From: Bennett, Richard - Communities
Sent: 07 October 2019 18:13
To: James Kirkham
Cc: Peart, Timothy - Communities; Plater, Roger - Communities; White, Joy - Communities; Nathanael Stock; Khan, Moaz - Communities
Subject: Great Wolf Lodge
Attachments: 05-Drainage schedule.docx

From: Bennett, Richard - Communities
Sent: 22 July 2019 12:59
To: Michael Smith <Michael.Smith@curtins.com>; Beaumont, John - Communities <John.Beaumont@Oxfordshire.gov.uk>
Cc: Drainage - E&E <Drainage@Oxfordshire.gov.uk>; White, Joy - Communities <Joy.White@Oxfordshire.gov.uk>
Subject: RE: Request for Comments on Proposed SW Strategy for Development

**Figure 4-2: Site Wide Existing Drainage Network**

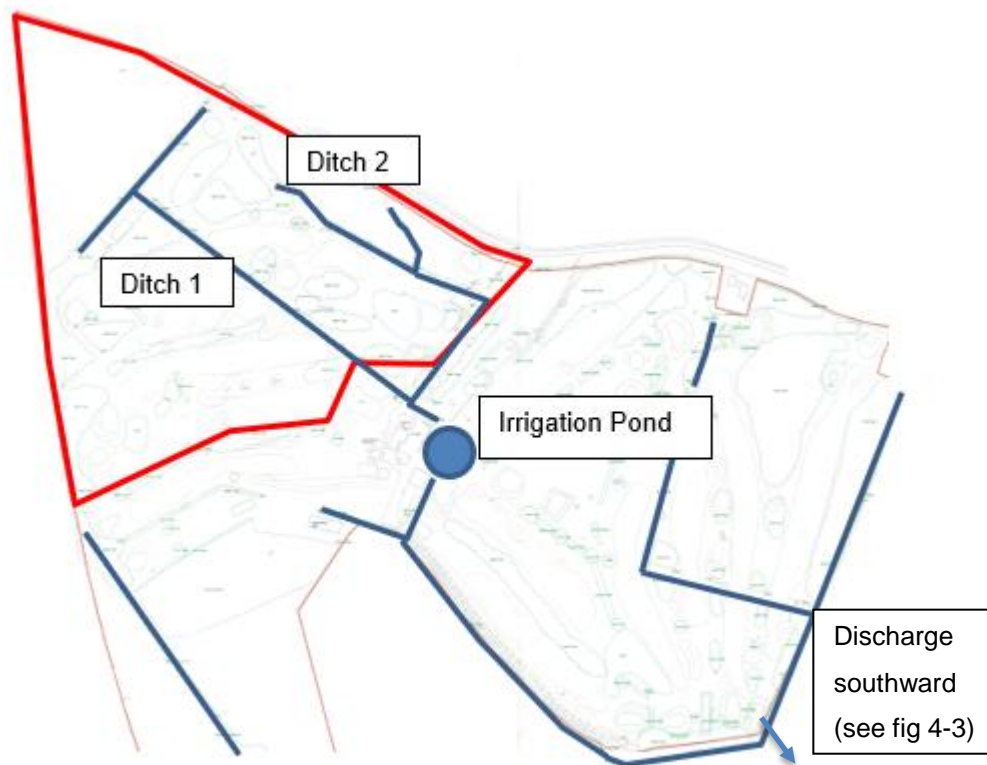
We have made it pretty clear throughout that the existing drainage features must be retained. The site is currently drained by a ditch network and three ponds, one of which is large enough to be classed as a lake. This is in an area of high groundwater.

These existing features are all planned to be removed and replaced by a strategy relying mostly on a piped system to underground storage which goes totally against the Oxfordshire Local Standards document.

Therefore the LLFA cannot support the proposed strategy and also the proposed layout, as the development will completely change and compromise the existing drainage regime, post development.

At the moment we have concerns that the layout is not allowing adequate space for above grounds SuDS and we see that existing drainage features are proposed to be removed which the LLFA cannot support.
